From: Thomas Callaway
Sent: 16 August 2016 16:29
To: Planning.Responses
Subject: RE: Planning Consultation on: P/76/16/PL

Engineers comments in respect to surface water drainage:

APPLICATION NO: P/76/16/PL

Description of Works: Construction of a building for the packaging, preparation & distribution of fresh foods with ancillary accommodation associated with the existing horticultural business, revisions to internal access road, car parking & hardstanding areas & landscaping & provision of a wetland. This application affects the setting of Listed Buildings.

TITLE Proposed Drainage Strategy	
SCALE 1:2000 @ A3	DRG. No. 8

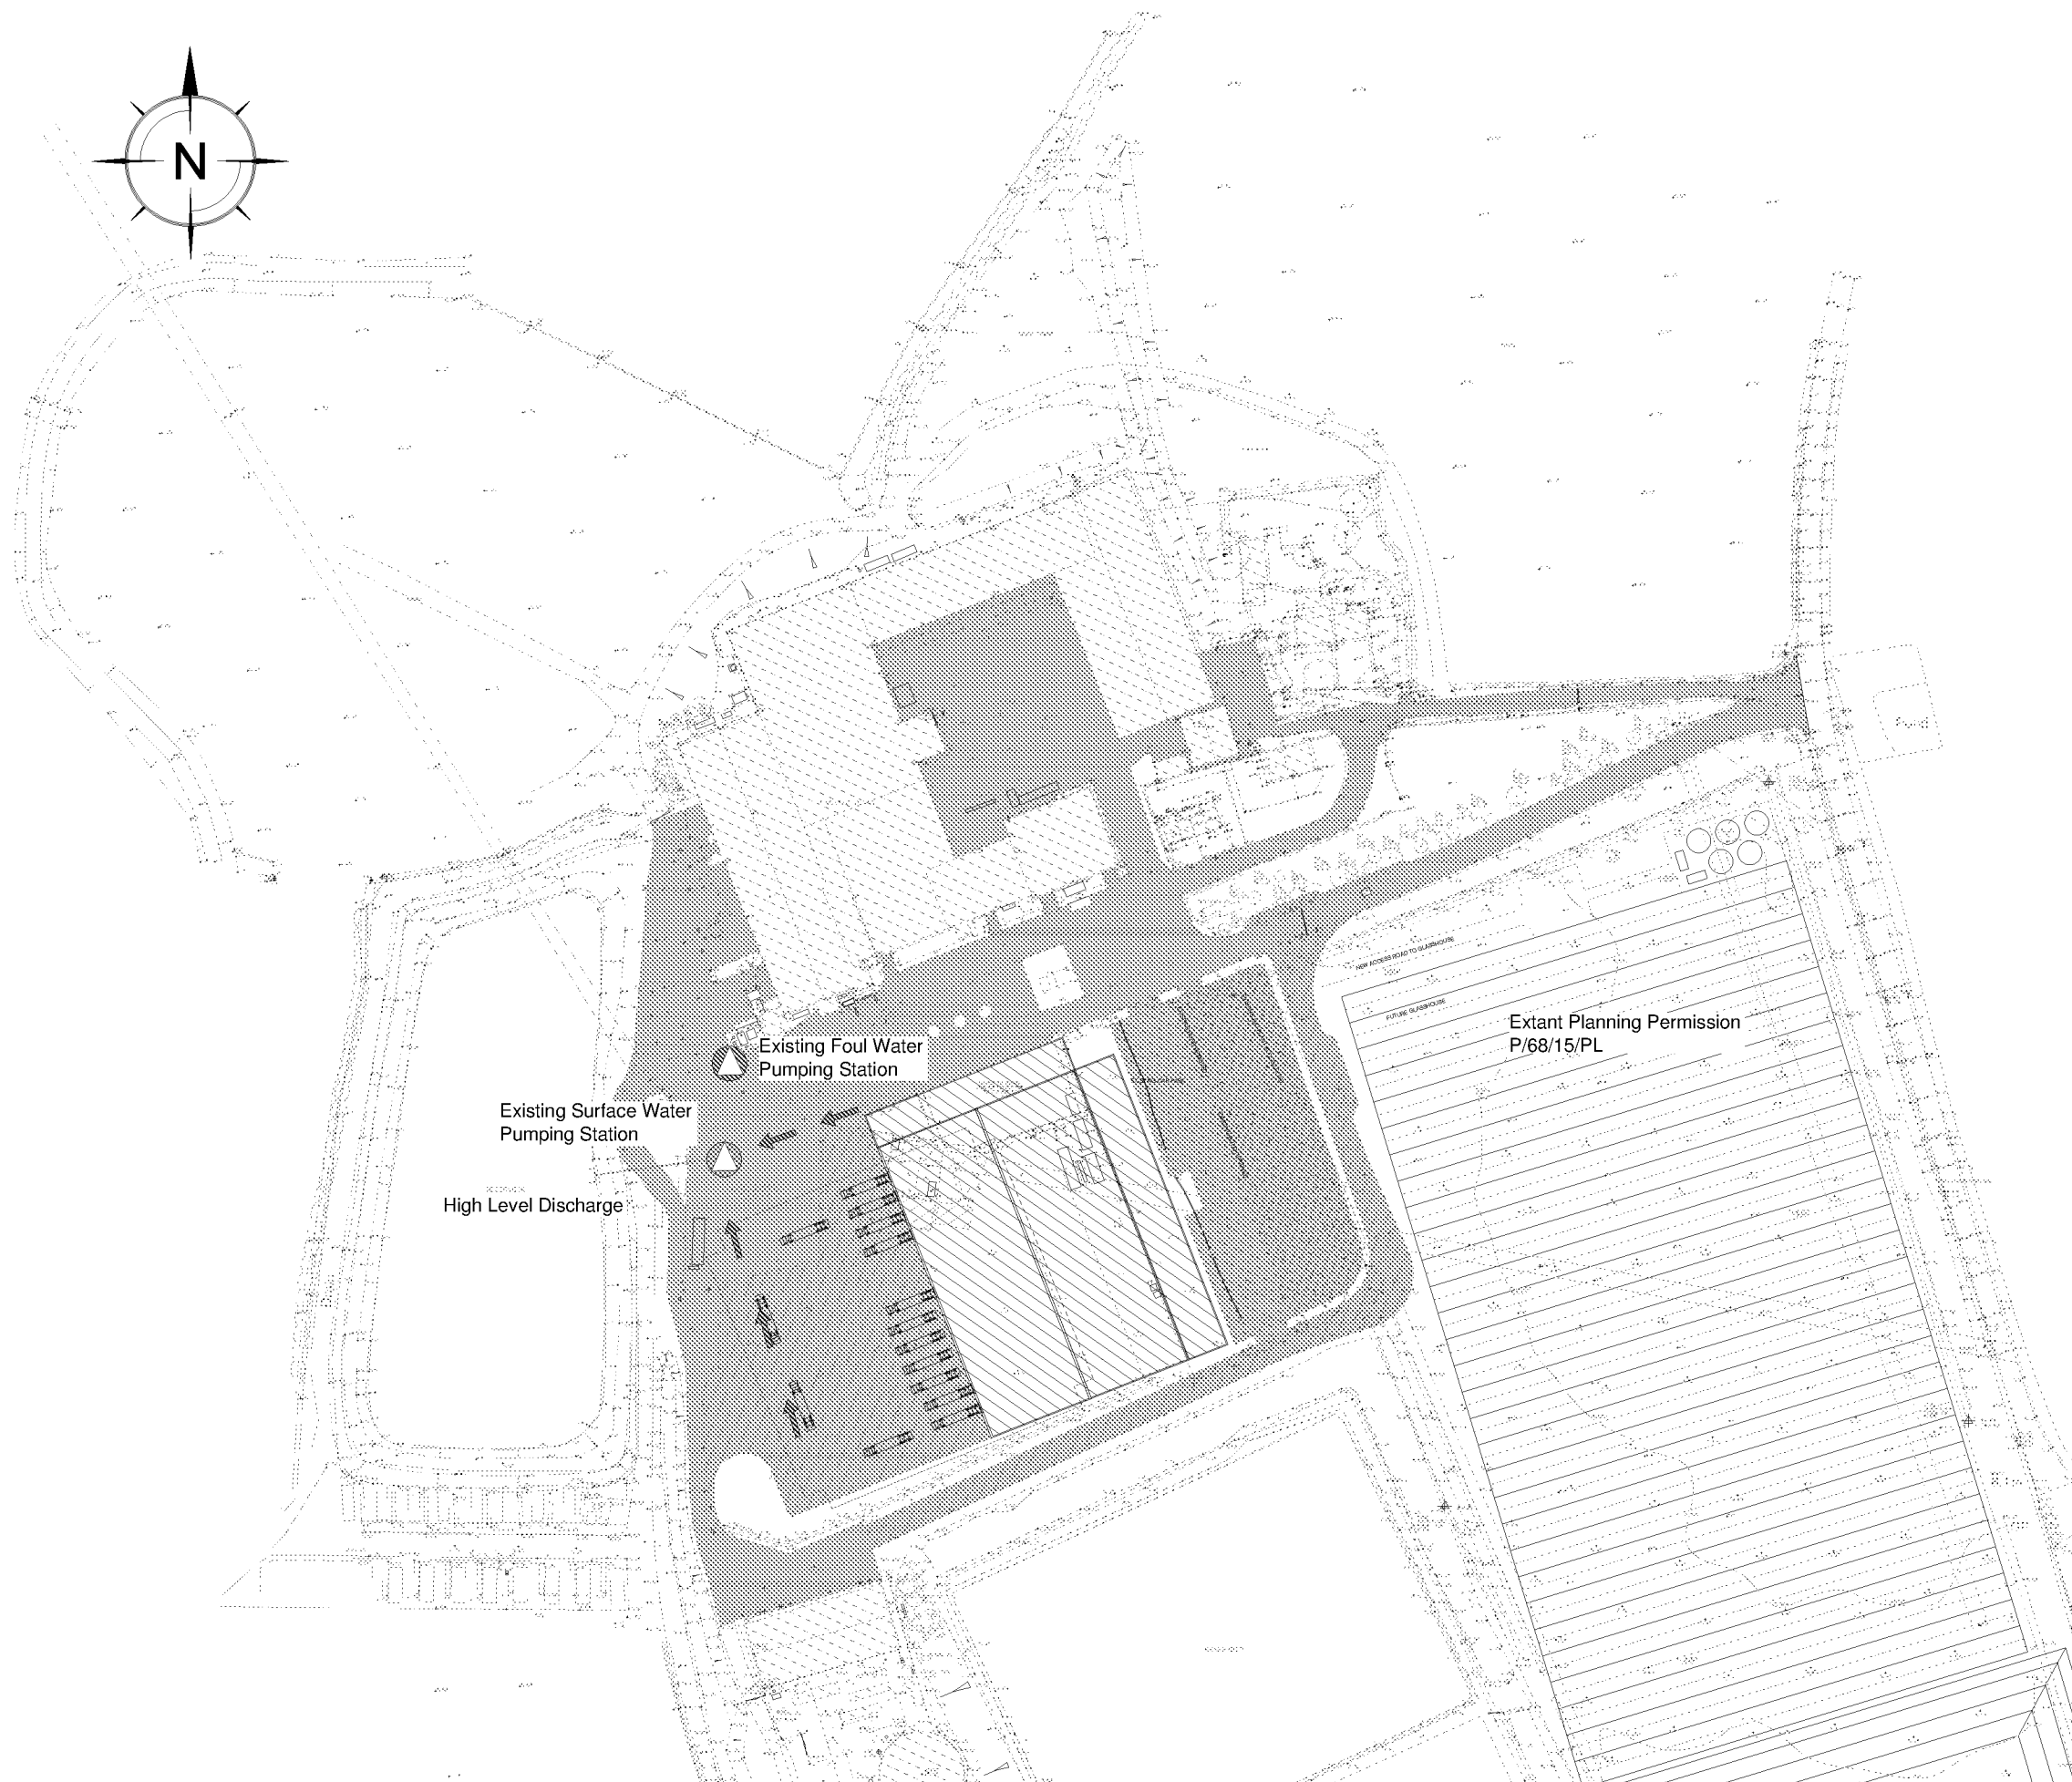
Infiltration to be investigated for new surface water drainage.

Infiltration rates for soakage structures are to be based on percolation tests undertaken in the winter period and at the location and depth of the proposed structures. The percolation tests must be carried out in accordance with BRE 365, CIRIA R156 or a similar approved method and cater for the 1 in 10 year storm between the invert of the entry pipe to the soakaway, and the base of the structure. It must also have provision to ensure that there is capacity in the system to contain below ground level the 1 in 100 year event plus 30% on stored volumes, as an allowance for climate change. Adequate freeboard must be provided between the base of the soakaway structure and the highest recorded annual groundwater level identified in that location.

Any SuDS or soakaway design must include adequate groundwater monitoring data to determine the highest winter groundwater table in support of the design. The applicant is advised to discuss the extent of groundwater monitoring with the Council's Engineers. Supplementary guidance notes are also enclosed for information.
